# Rezoning Transportation Analysis

Petition Number: 2020-109

**From: Robyn Byers, PhD**  
[Robyn.Byers@charlottenc.gov](mailto:Robyn.Byers@charlottenc.gov)  
704-336-7404

Date	Description
09-18-20	First Review (LJ)
10-19-20	Second Review (LJ)
11-30-20	Third Review (LJ)
12-28-20	Fourth Review (LJ)

EX01-REZONING PLAN

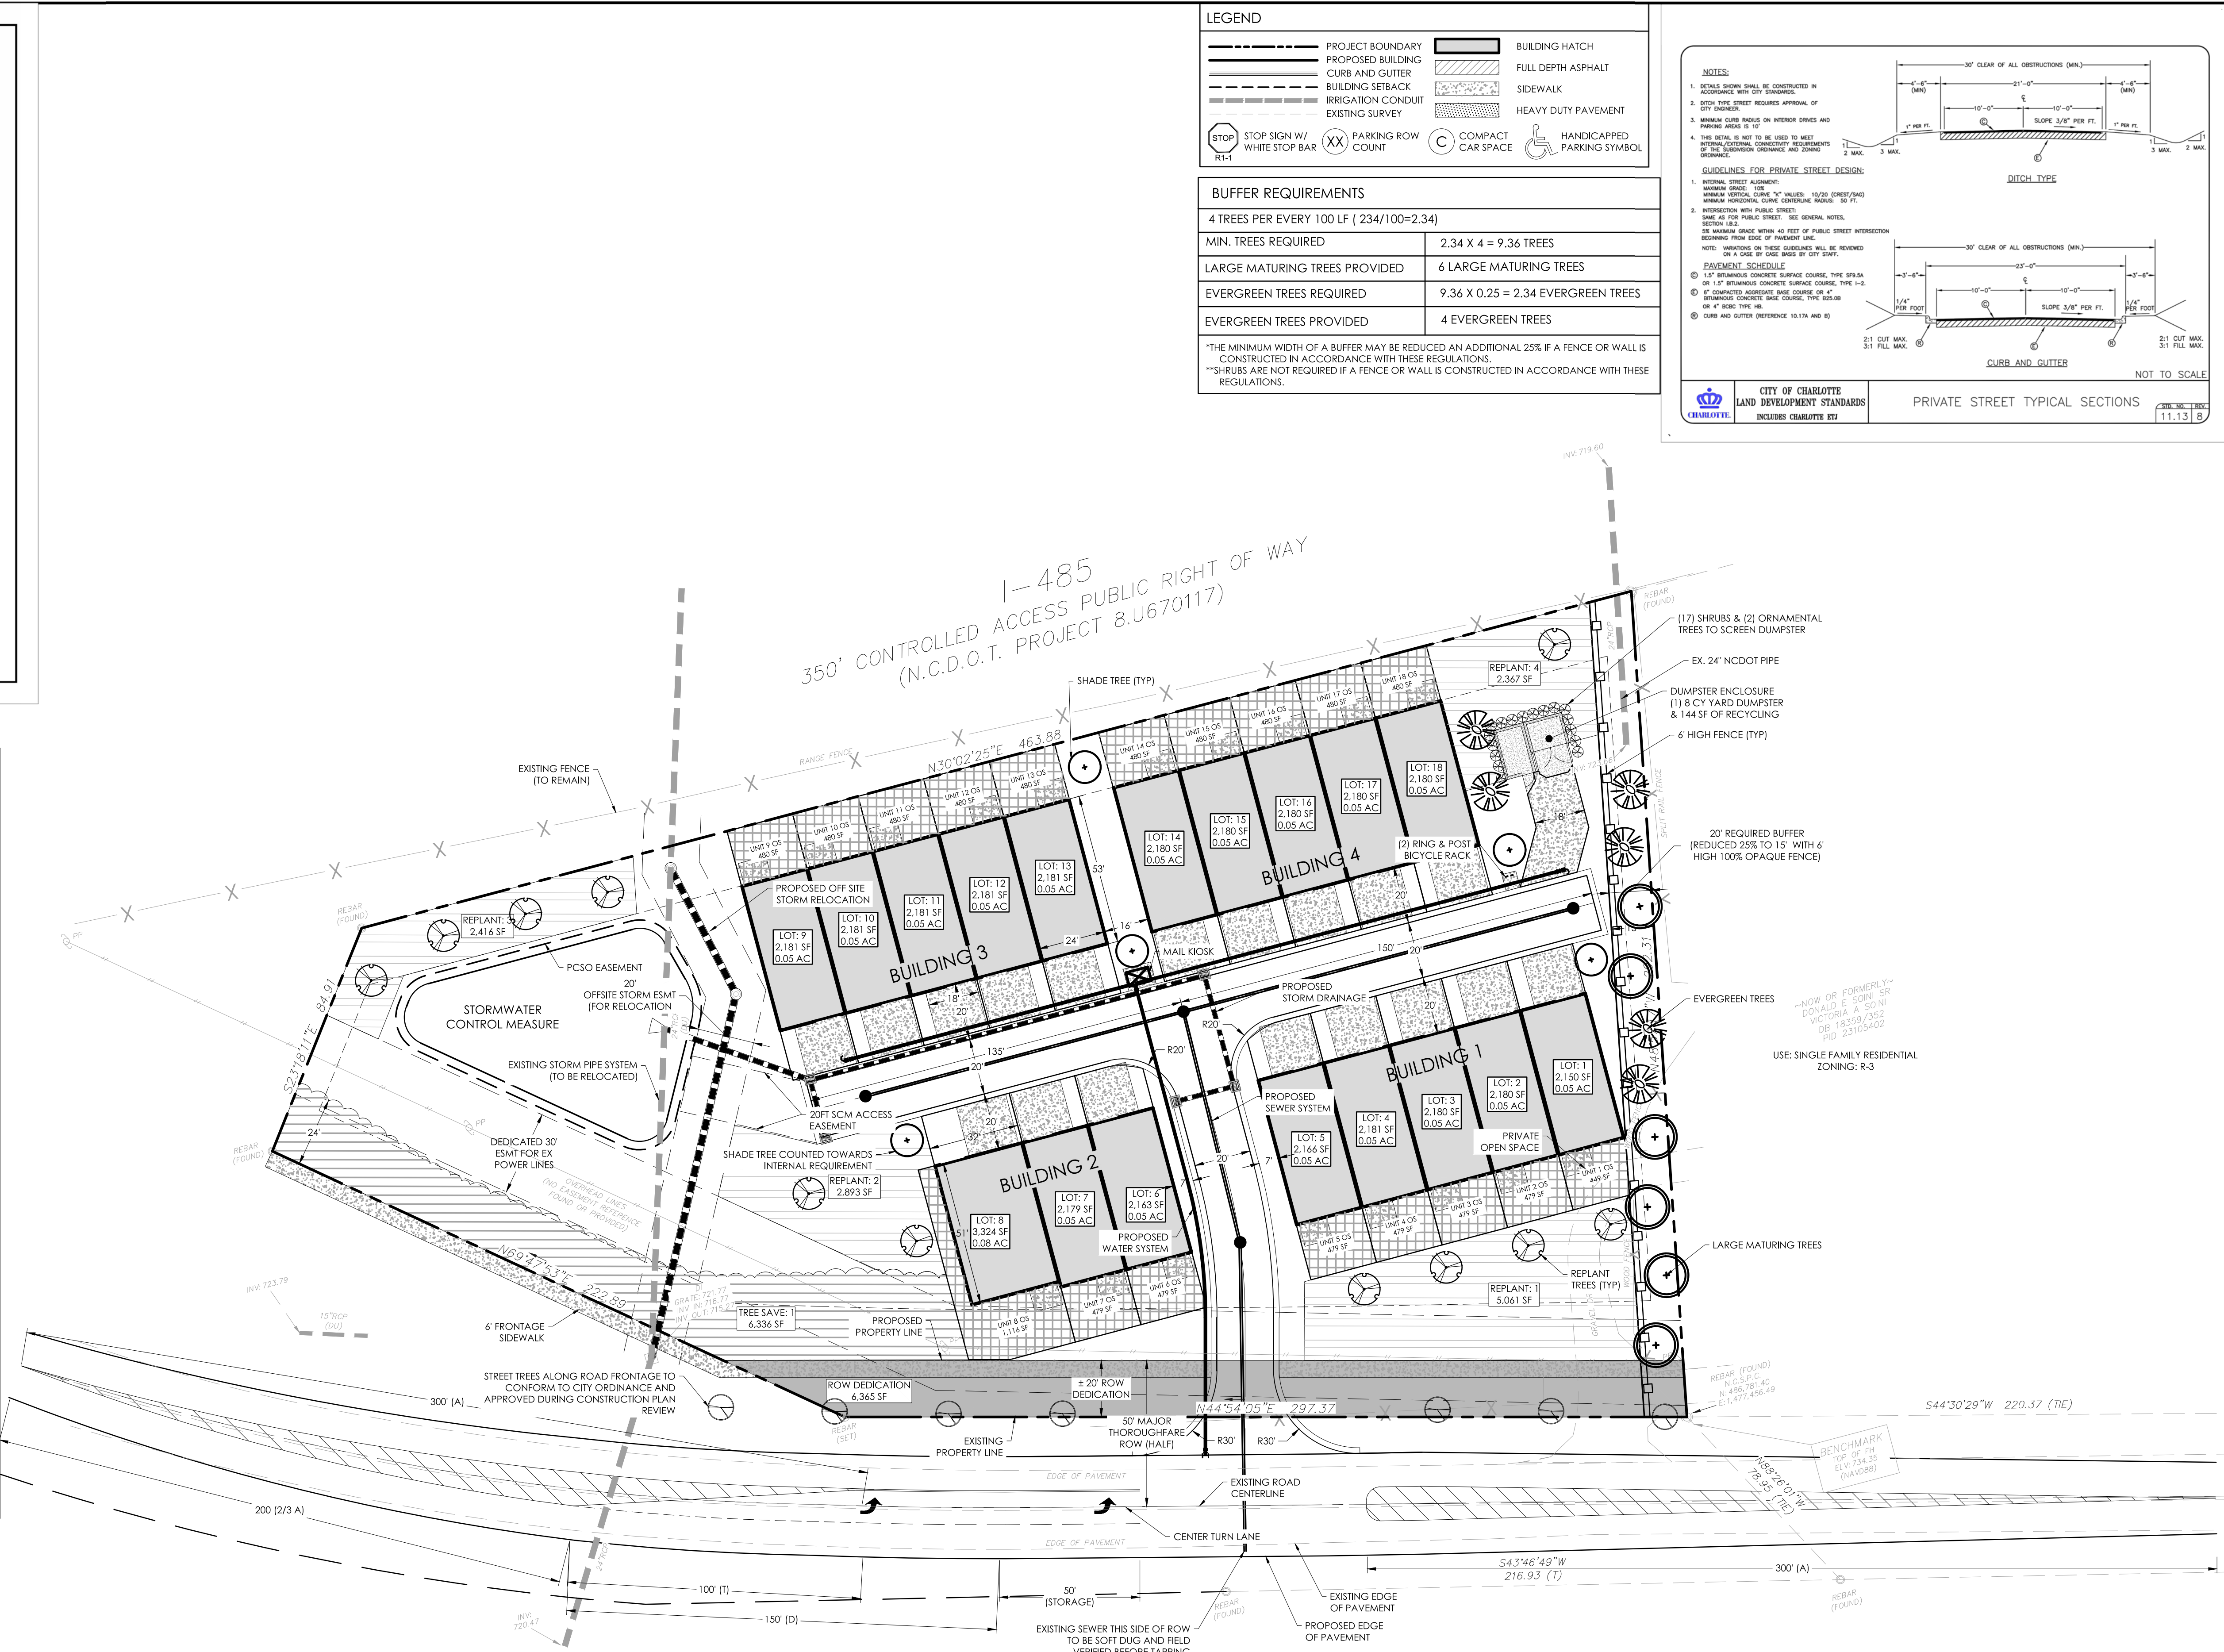
3. The site plan and conditional note(s) need to include an 8-foot planting strip on McKee Road per Chapter 20/Chapter 19. CDOT requests a 12-ft Multi Use Path in lieu of the required 6-foot sidewalk per the Charlotte BIKE Policy (primarily due to land use context and lack of frequent driveways). Both items need to be labeled and dimensioned from the back of curb and gutter and road centerline on the site plan.

Begin the Multi Use Path where the property line changes direction and runs parallel with McKee Road.

5. **Rescinded** Provide ISD along McKee Road for driveway, both horizontal and vertical included to show standard meets NCDOT standards. **Petitioner will address and provide the vertical ISD to meet NCDOT standard during permitting approval.**
